**Lindfield Learning Village (SSD 8114)
Notice of Exhibition**

Thank you for your correspondence dated 20 June 2017 requesting Transport for NSW (TfNSW) comment on the above proposal.

TAB A – Detailed Comments on the TfNSW Request for Additional Information

Figure 21: Overall site plan showing bus facilities

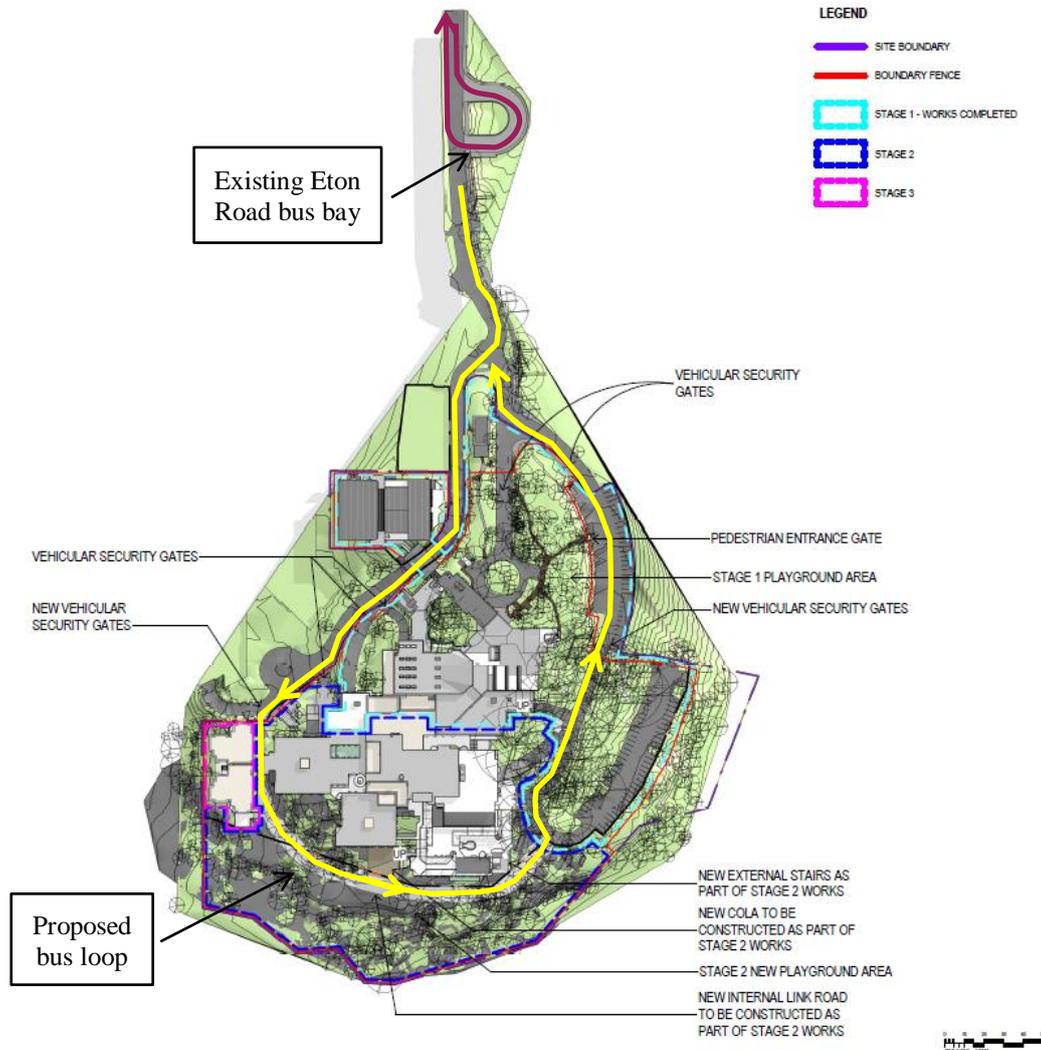
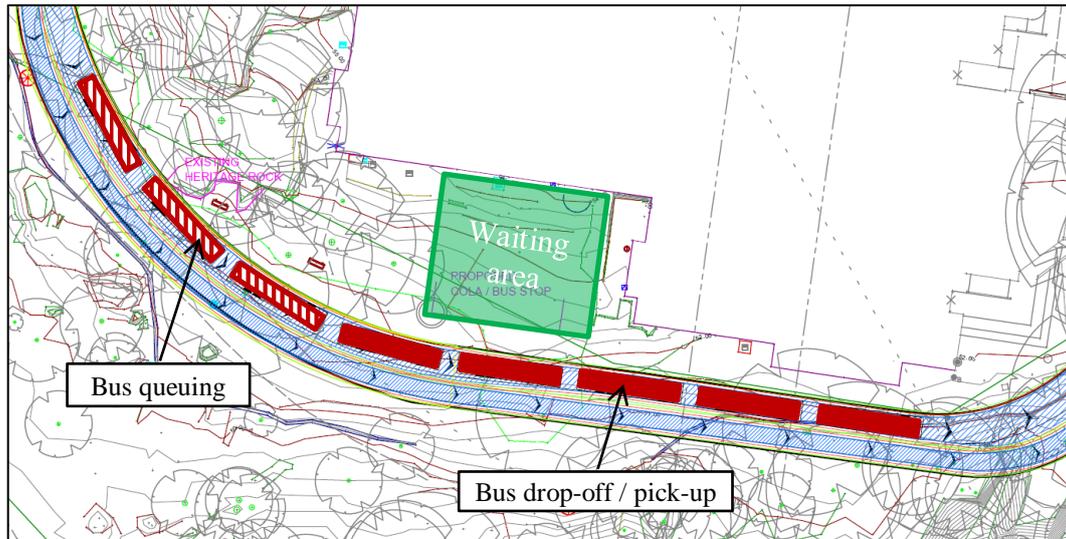
- TfNSW requests that the proposed bus stop design is revised or relocated having regard for the number of school buses potentially using the proposed bus bay at the same time, the ability to overtake other buses and/or exit their respective bays and the safety implications of the design for children and less mobile patrons.

It is likely that a number of school buses would be using the proposed bus bay at the same time. Due to the curvature and dimensions of the current design, no buses will be able to overtake other buses and/or exit their respective bus bay if there were other buses stopped at any other stops. Furthermore, the curved design would potentially pose a safety risk for children and less mobile patrons as the bus doors would open directly onto the road rather than the footpath.

TfNSW requests that the proposed bus stop design is revised or relocated having regard for the above comments.

TfNSW advises that the existing bus bay would potentially be more suited to a pick-up and drop-off location for motor vehicles.
